Response to WSCC Strategic Planning Consultation Comments dated 6 September 2012

**Roundstone Lane, Angmering
Arun Planning Application A/82/12**

Barratt David Wilson Southampton

23 November 2012

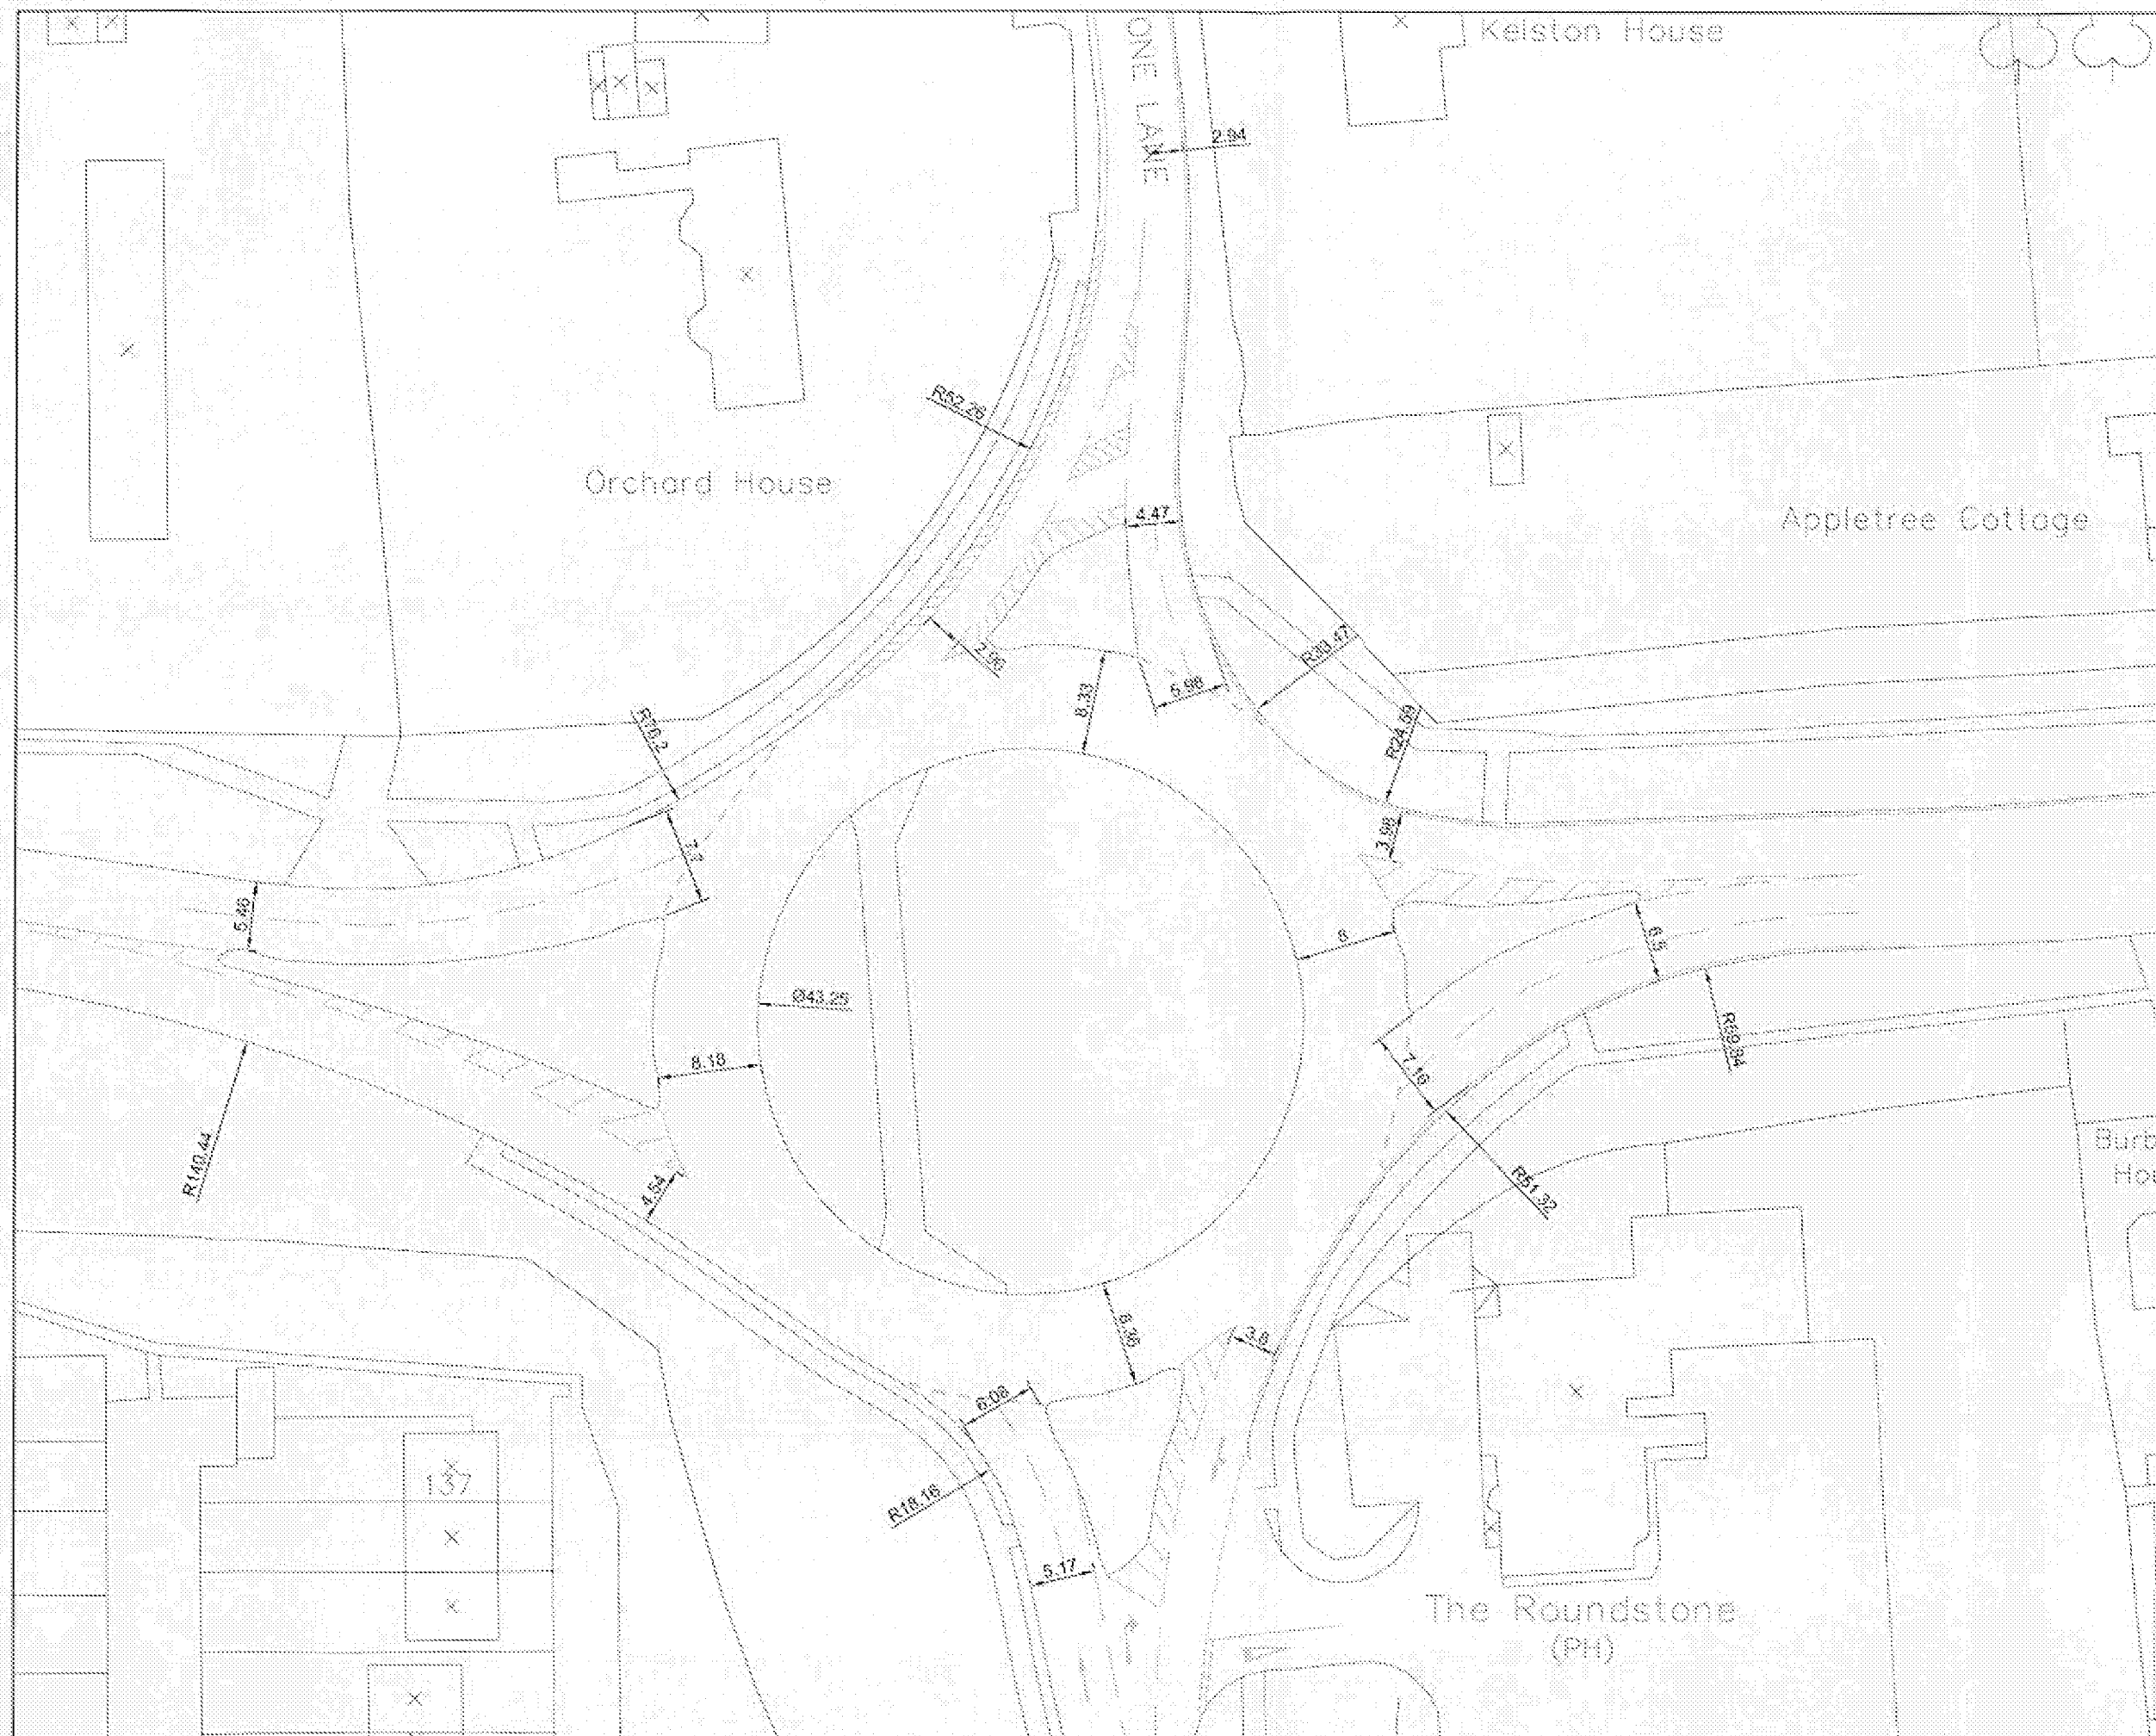
'The junction of the A259 and Roundstone Lane appears to have a narrow exit arm from Roundstone Lane which reduces capacity on the arm. Further information should be provided on this aspect of the junction and whether alterations to the kerb line would be beneficial.'

Drawing 22067/110 which shows the existing kerb and white lining layout together with photographs of this location are attached in Appendix 2 at the rear of this note.

The entry arm onto the roundabout is two lane on its approach and modelling of this roundabout confirms that the existing highway geometry does not present any capacity issues.

The situation where a large vehicle straddles both entry lanes and restricts the ability of two lane entry only causes a momentary delay and it can be seen that the small queues clear very quickly. The proposed development is residential and would therefore not increase HGV flows. The existing two lane entry is sufficient for two cars abreast.

Given the lack of capacity problem and small traffic impact no highway improvement was offered with the planning application and we remain of the view that this location is not in need of junction capacity improvement due to development.

|                                   |          | Drawn                                                                                  | 4528:P02  |

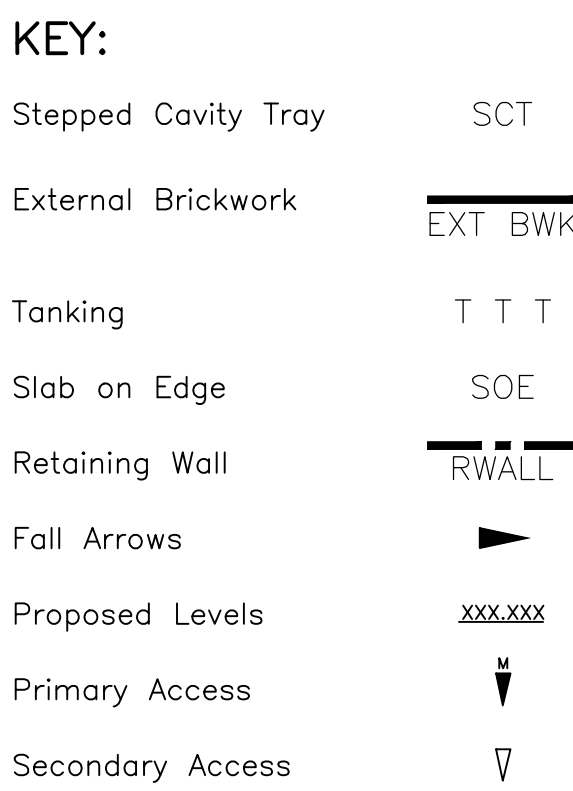
'Internal road layout: It would be helpful if a more detailed plan could be provided showing how provision will be made within the site for pedestrians, cyclists and mobility-impaired people. It is not clear from the refuse tracking layout (plan 4528:P90) whether footways or shared surfaces will be provided, nor whether access for emergency vehicles has been considered. Evidence that the Fire & Rescue service has been consulted should be provided.'

The architectural colour layout plan attached to the planning application shows footways adjacent to most carriageways and also indicates pedestrian crossing locations which would all include tactile paving as part of detailed design. There are small areas of shared surface cul-de-sacs.

Vehicle tracking analysis was included for the entrance and internal streets including large refuse vehicles (which by worst case includes fire and other emergency vehicles) which demonstrates the physical layout is appropriate which can be agreed in detail as part of a section 38 technical approval. The layout is designed to be in accordance with Part B of Building Regulations.
